M60/M62/M66 Simister Island Interchange Project

The Examining Authority's (ExA) Consultation draft Development Consent Order (dDCO)

Schedule of ExA's recommended amendments to the applicant's dDCO submitted at Deadline 5 [REP5-005]

Client: national highways  
 Project: M60/M62/M66 SIMISTER ISLAND INTERCHANGE

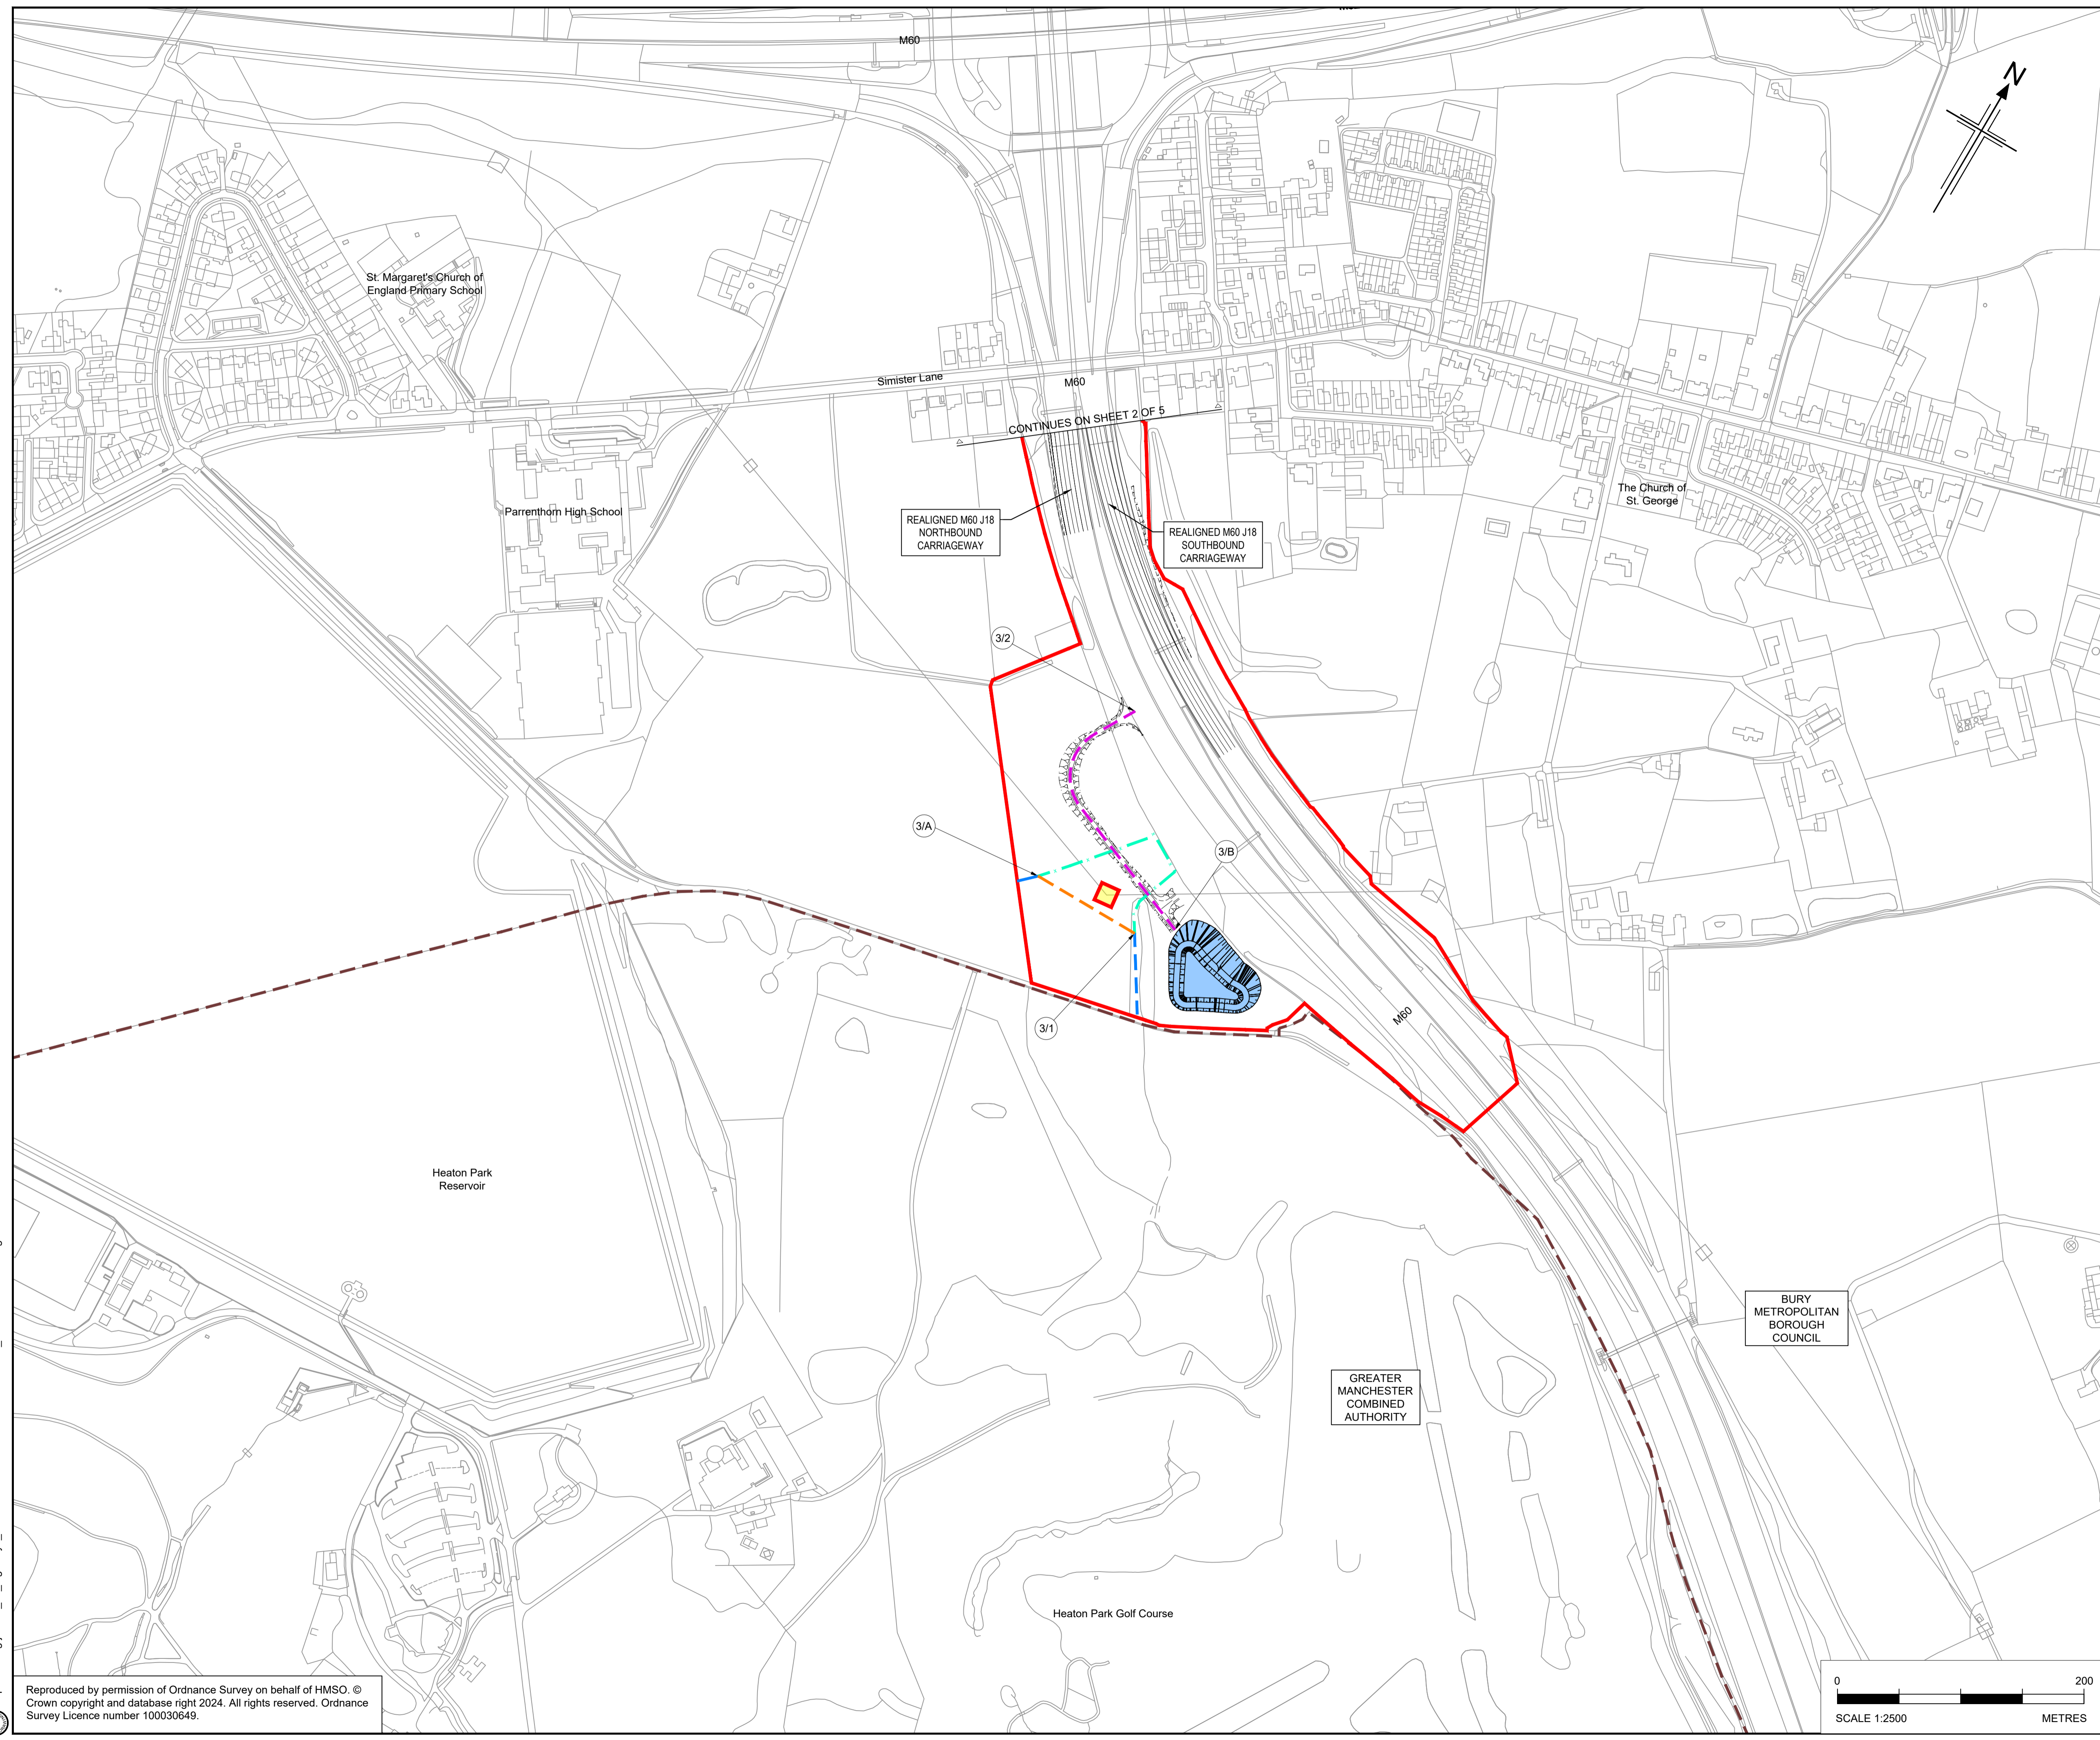
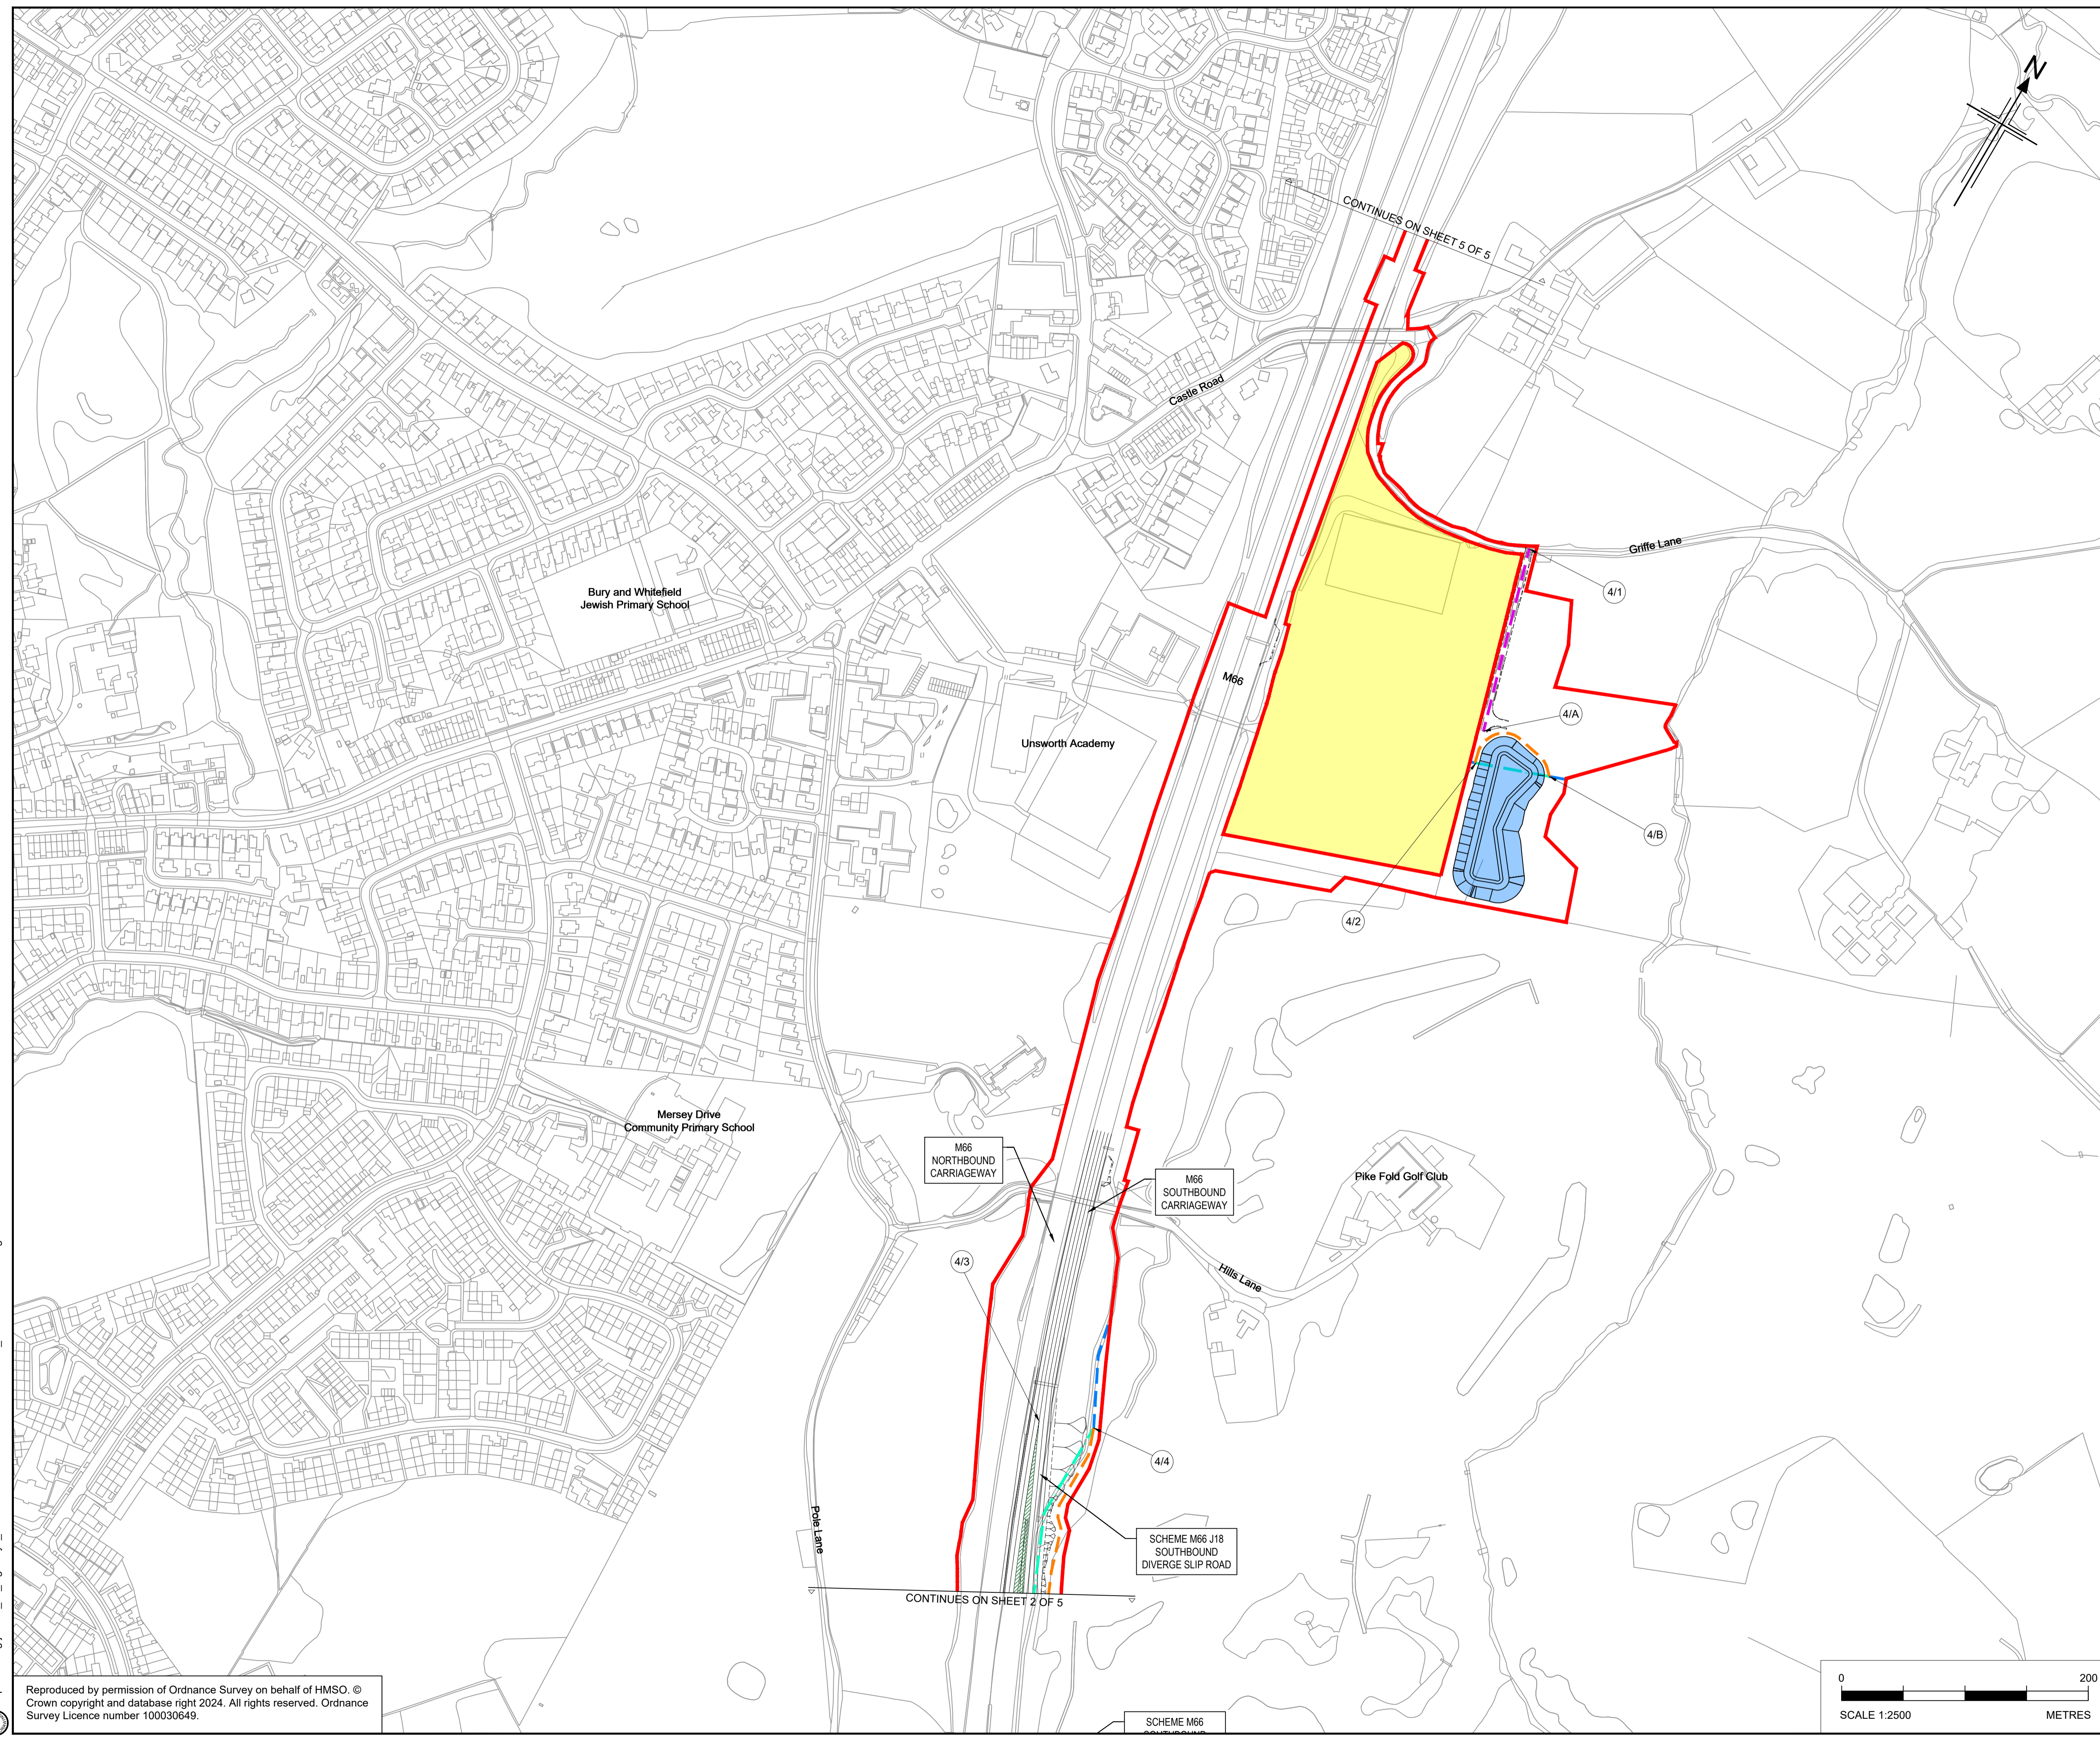
5.	13. Classification of roads etc.	(4) The private means of access specified in column (2) of Part 3 (private means of access) of Schedule 3 and identified on the	(4) The maintenance accesses and private means of accesses specified in column (2) of Part 3 (private means of access) of	To improve precision by clarifying that the article also includes the 'maintenance accesses' as identified on the Streets, Rights of Way & Access

No.	Article / Schedule	Text as set out in the draft DCO [REP5-005]	ExA's Recommended Amendment	Reason and Notes
		streets, rights of way and access plans are to be constructed by the undertaker in the specified locations and open for use from the date on which the authorised development is open for traffic.	Schedule 3 and identified on the streets, rights of way and access plans are to be constructed by the undertaker in the specified locations and open for use from the date on which the authorised development is open for traffic.	Plans [APP-008], noting the applicant's response to ISH1 Action Point (AP) 8 [REP1-024] that the article is intended to cover both the both the maintenance access tracks listed in Schedule 3, Part 4 and the private means of access.
